Light Valley Solar

08.17 The Applicant's Response to North Yorkshire Council's Local Impact Report

Document Reference: EN0110012/APP/LVS/08.17

The Applicant's Response to North Yorkshire Council's Local Impact Report

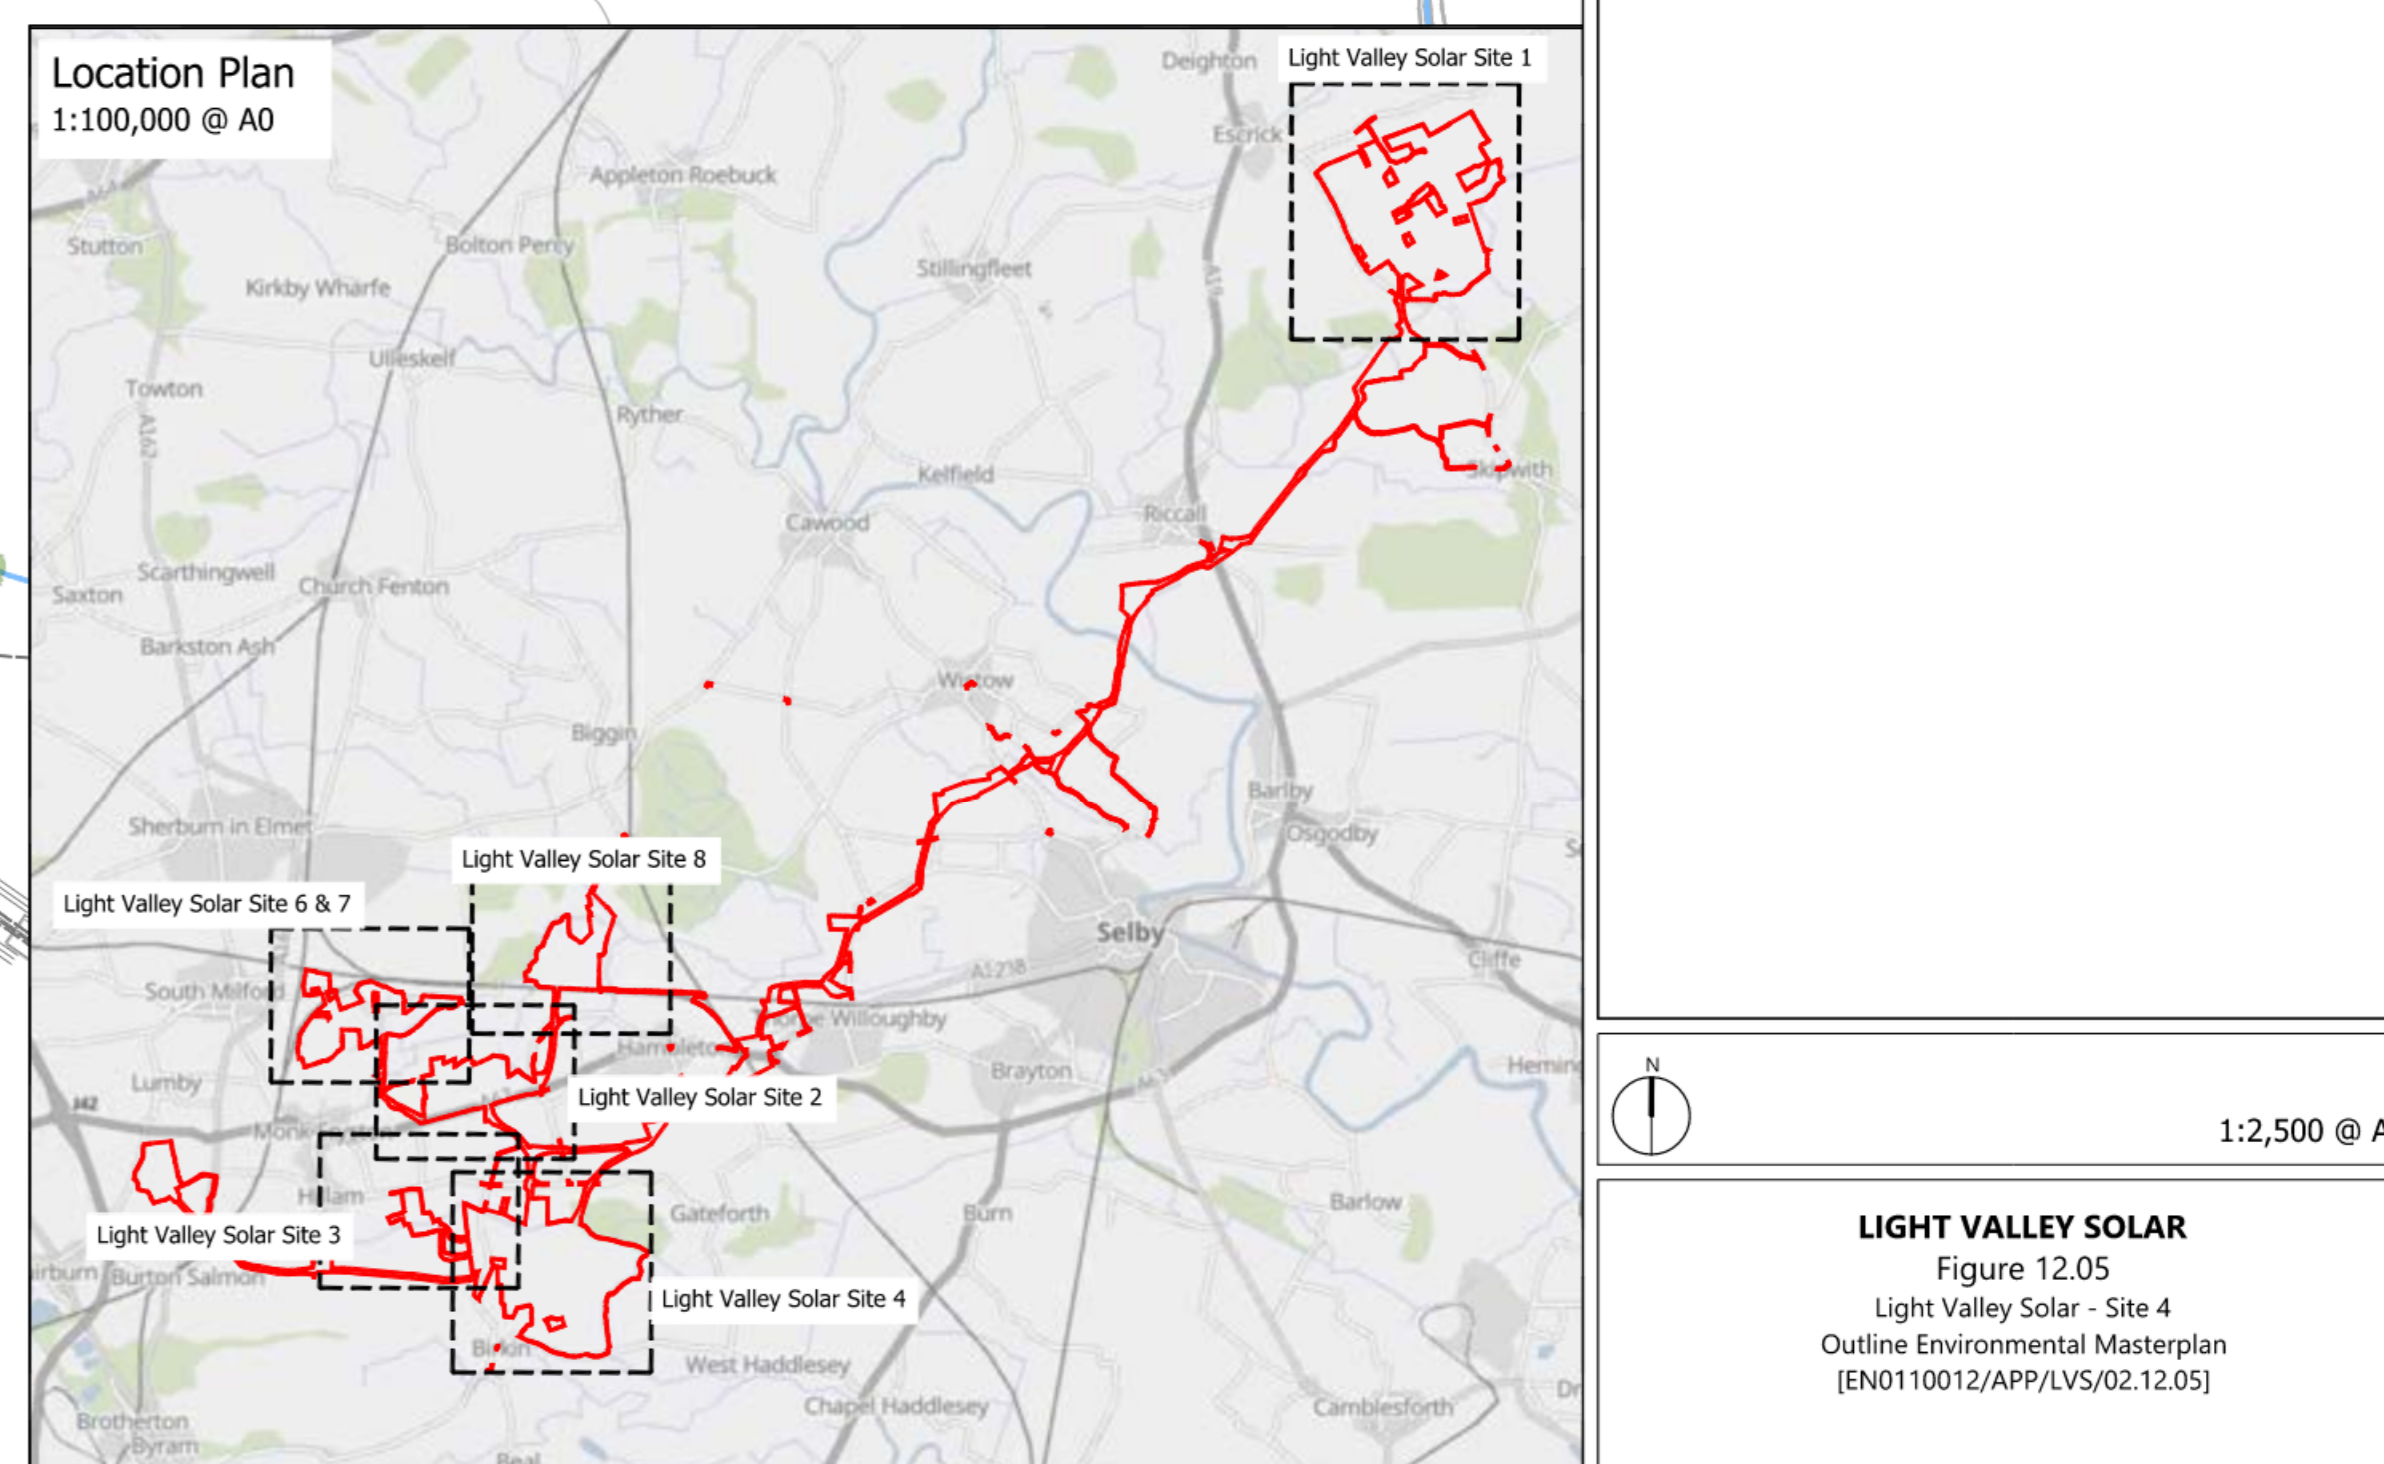
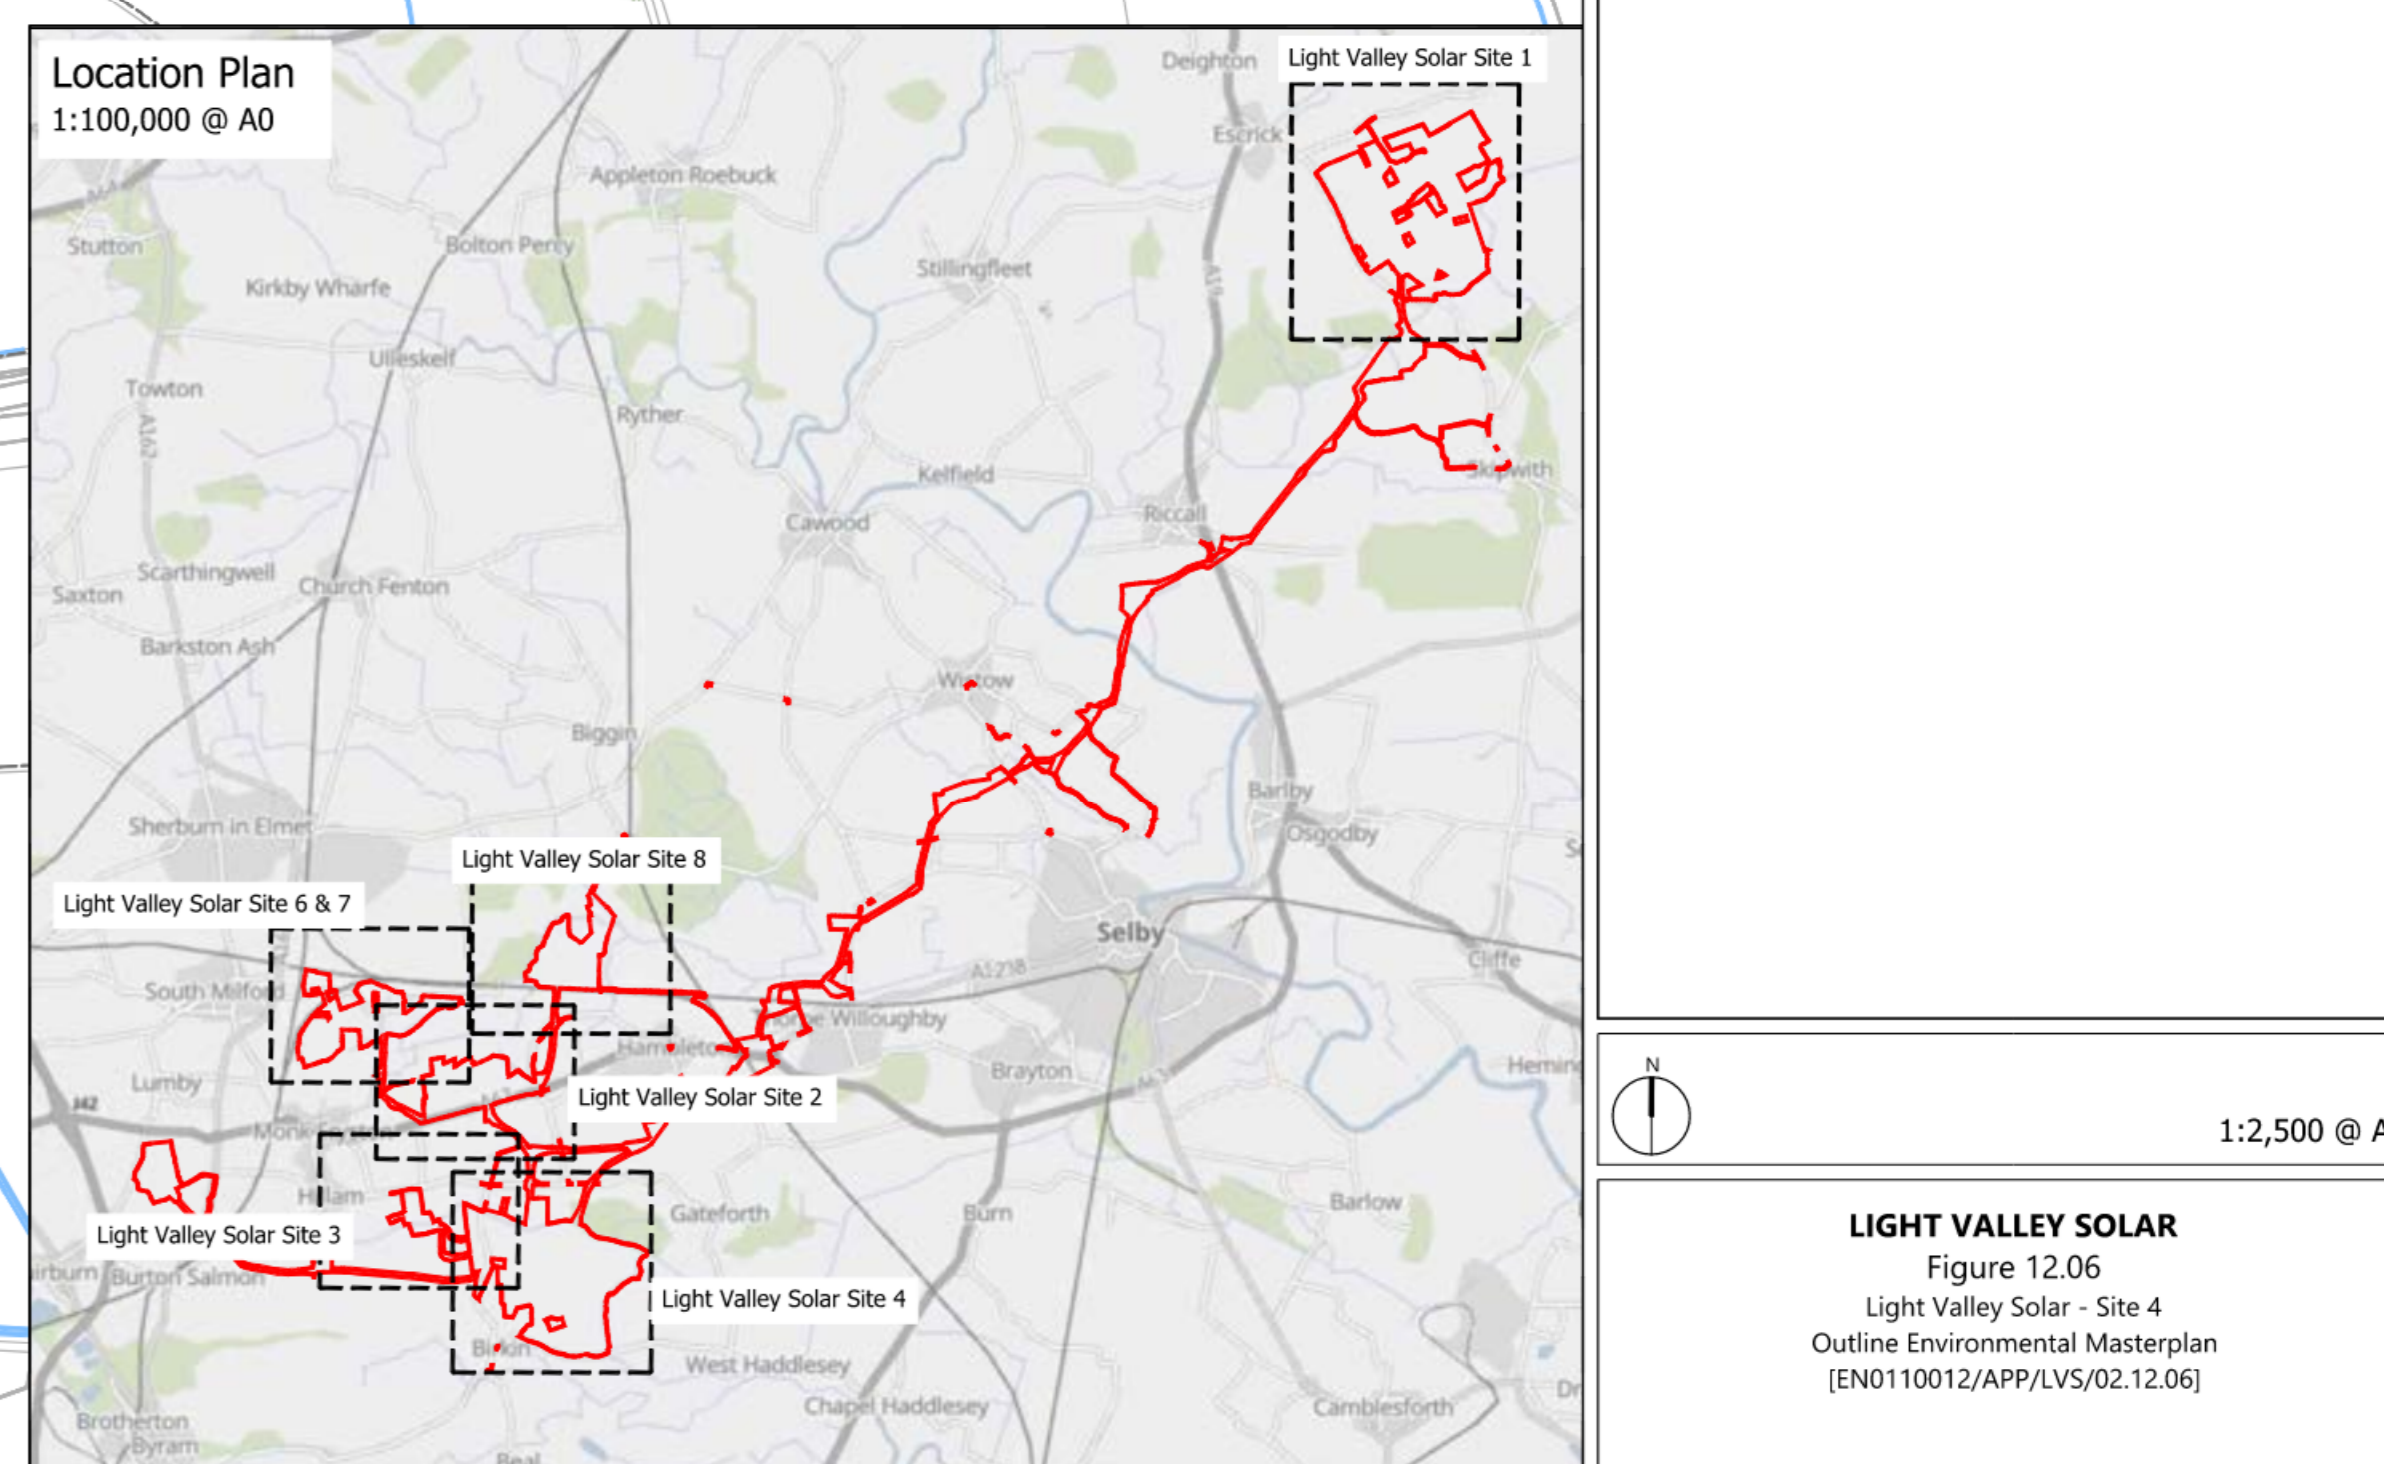
LIR-NYC-76	Public Rights of Way Landscape and visual Impact	In solar development site 4, there are long stretches of PRow enclosed by solar arrays. The applicants should look at soft landscaping and screening to help mitigate the visual impact as this currently provides a corridor effect.	The Design Parameters and Commitments document [updated alongside this submission] establishes a minimum offset of 15m either side of PRow within the Order Limits, equating to a corridor of 30m. The Outline Environmental Masterplans (OEM) [updated alongside this submission] illustrate the network of public rights of way (PRow) that intersect with, parts of the Proposed Development. These plans also show where these PRow would be stopped up or diverted and where additional permissive paths are proposed to enhance the network, providing greater choice of routes and permeability through the landscape that does not currently exist. Where PRow are located within SDS, substantial space is provided to accommodate offsets and proposed hedgerow and tree planting, as illustrated on the OEM, for example the two public footpaths that run through SDS, as shown in OEM Figure 12.05. This provides adequate space for planting to visual screen and integrate proposed solar panels within views from these PRow in the longer term.
